**Subject:** FP/139/19/OUT - Land south of garage compound & East of 12 Alfriston Close Felpham PO22 6QE

Further to comments provided by my colleague Kyran Schneider on 18<sup>th</sup> July 2019, the WSCC Area Engineer has contacted me with concerns regarding this proposal in relation to the footway. Specifically they are concerned that the applicant intends to build on this land, which is publically maintained highway.

FP/139/19/OUT, Land south of garage compound BLOCK PLAN 1:200 scale

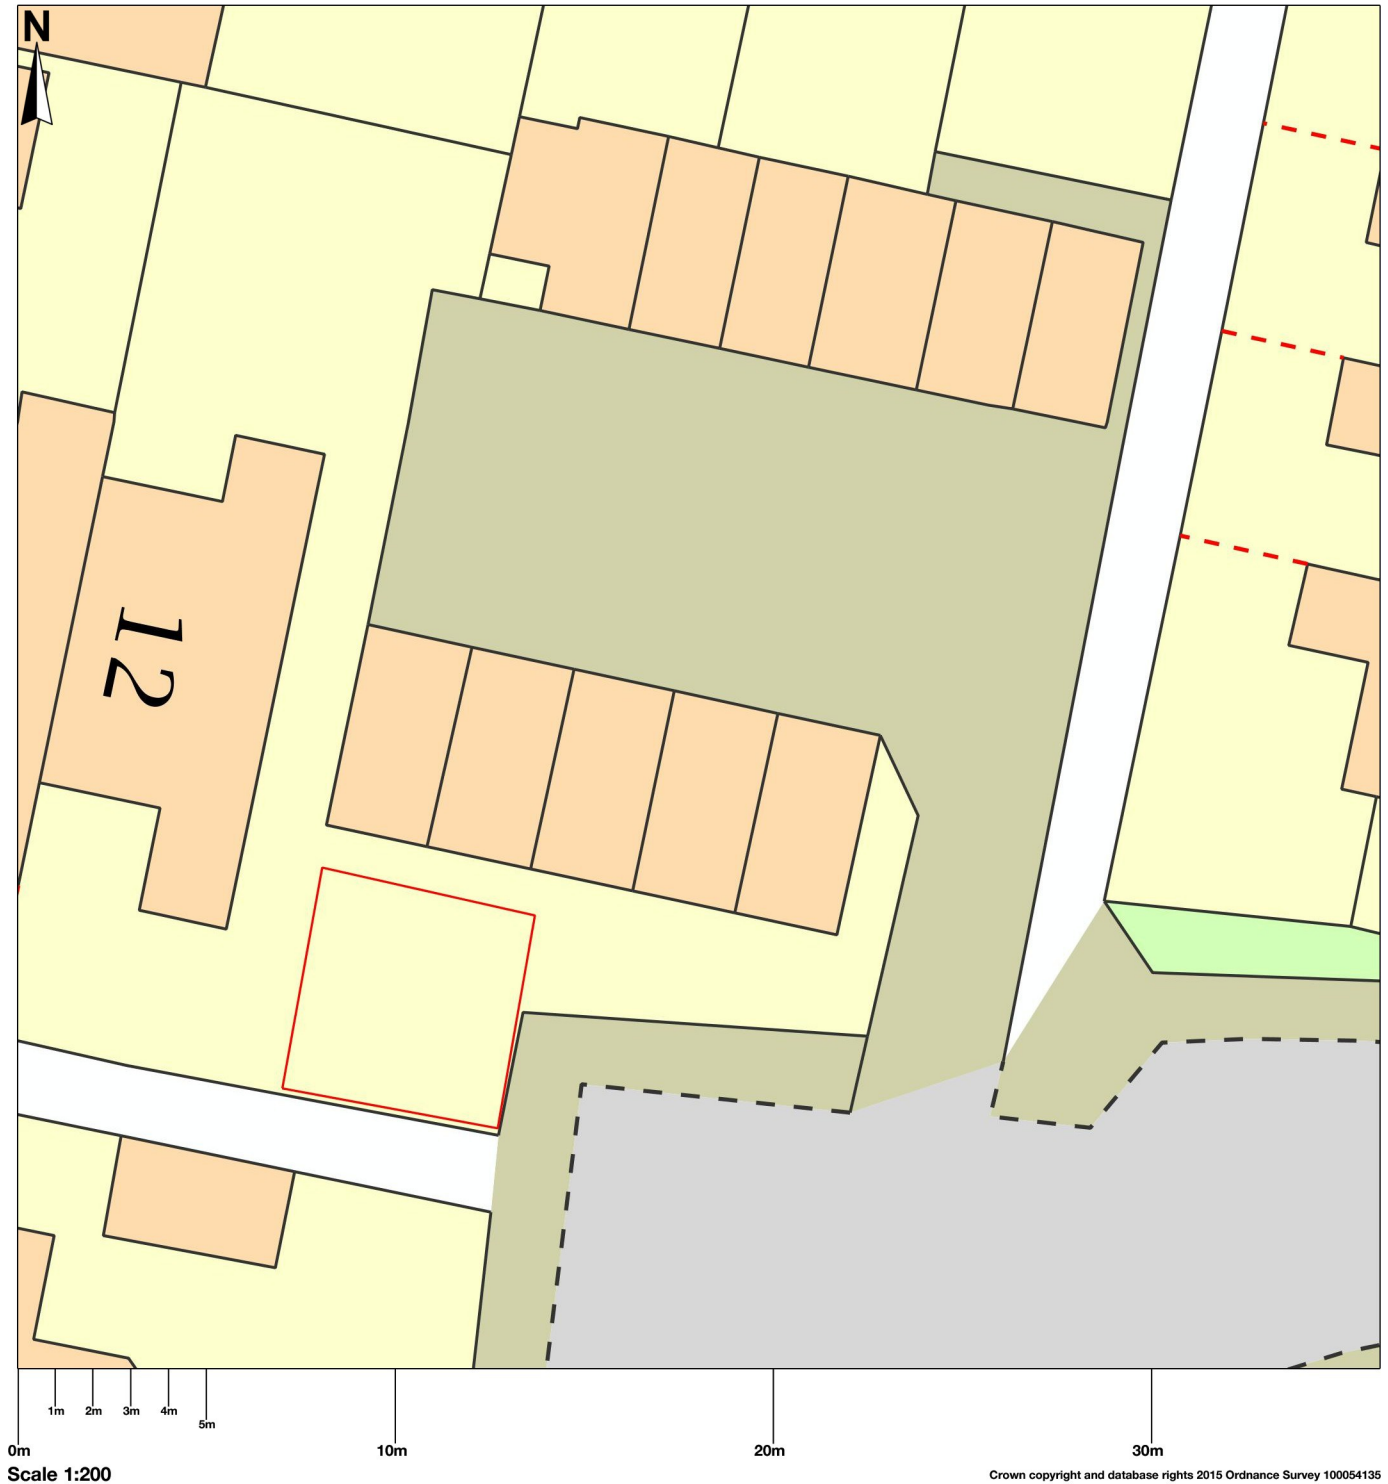
Having inspected local mapping, it appears that the whole site is classified as publically maintained highway. In order for the land to be incorporated into the site, the highway rights would need to be formally removed by way of a Stopping Up Order. This is controlled by Section 247 of Town and Country Planning Act and would be subject to a separate process administered by the Department for Transport's National Casework Team. The Highway Authority along with other statutory undertakers and interested parties would be consultees in this process. There is also no guarantee that this process would be successful. The comments made here would not constitute the Highway Authority's formal position regarding any future Stopping Up. The applicant should be aware that the LHA would not wish to see any loss of footway width in this location. This does appear to have been acknowledged by the applicant in comments dated 29<sup>th</sup> July.
